# CITY OF ALBUQUERQUE

October 5, 2017

**Re: Delgado Dwelling, 1703 Lomas NW**  
**Request for Certificate of Occupancy**  
**Transportation Development Final Inspection**  
Architect's Stamp dated 11-15-17 (J13-D203)  
Certification dated XX-XX-17

TRAFFIC CIRCULATION LAYOUT PARKING AREA PLAN

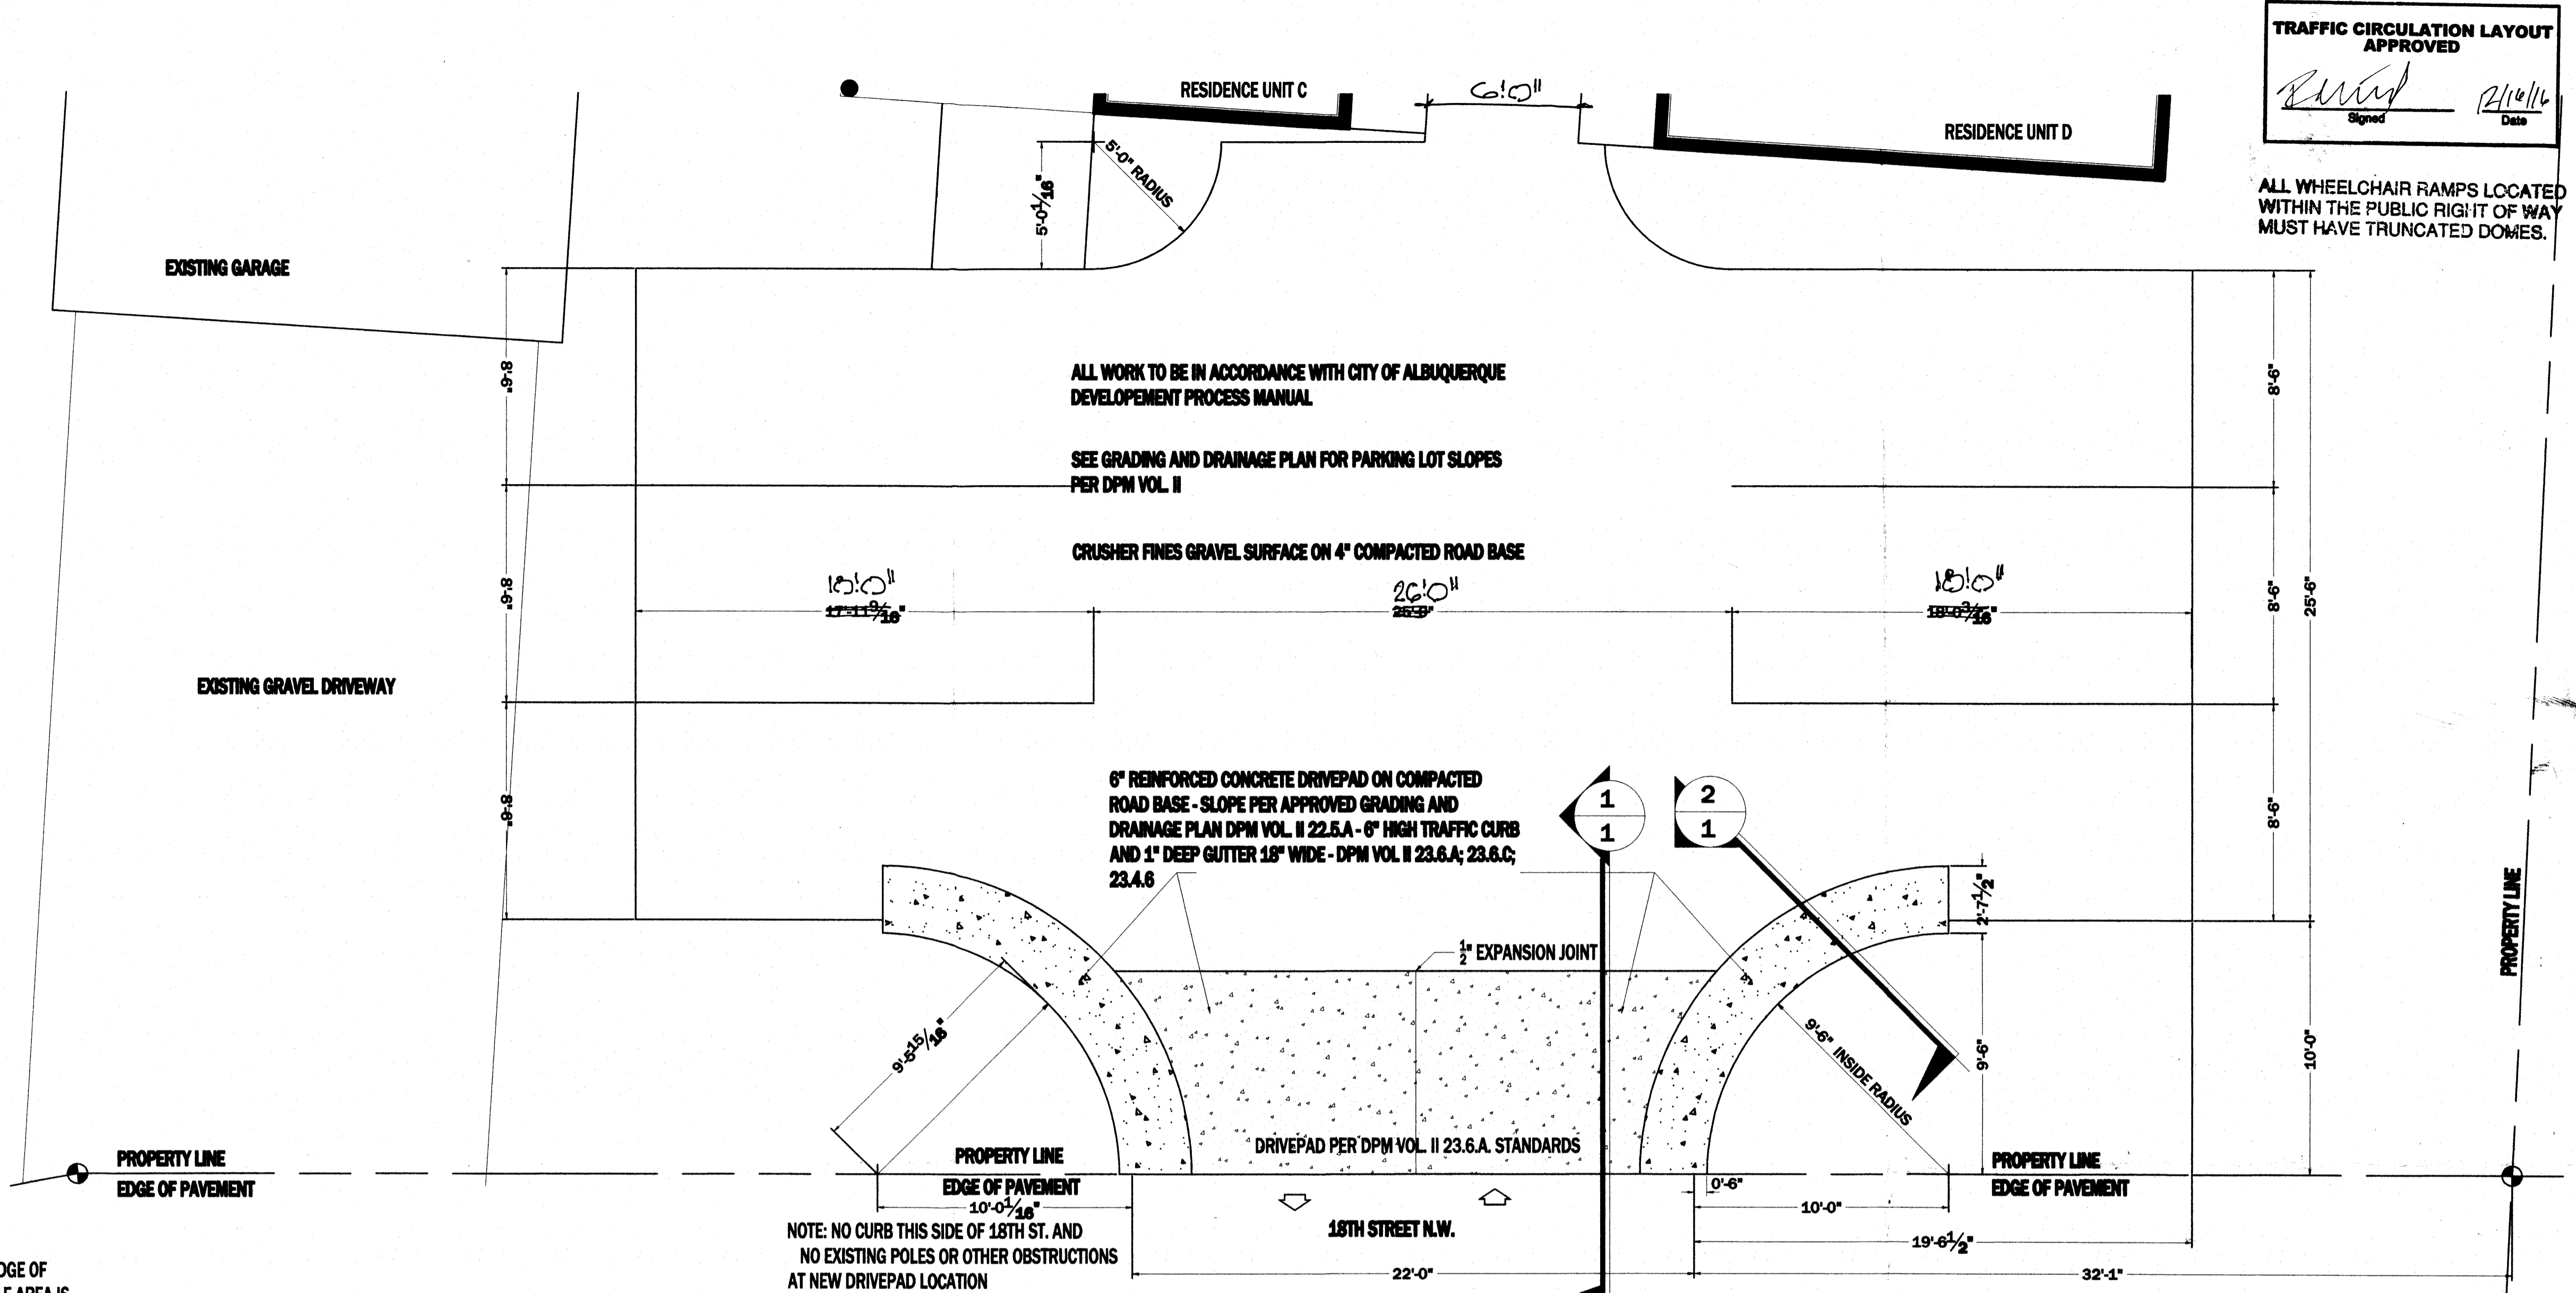
- The redline TCL must have the original transportation approval stamp.
- The certification letter must be stamped and signed by an architect or engineer  
licensed with the State of New Mexico.
- Designated disabled parking spaces and pedestrian pathways must be paved  
with 2" asphaltic pavement or equivalent per City of Albuquerque standards to  
ensure compliance with Federal Guidelines.
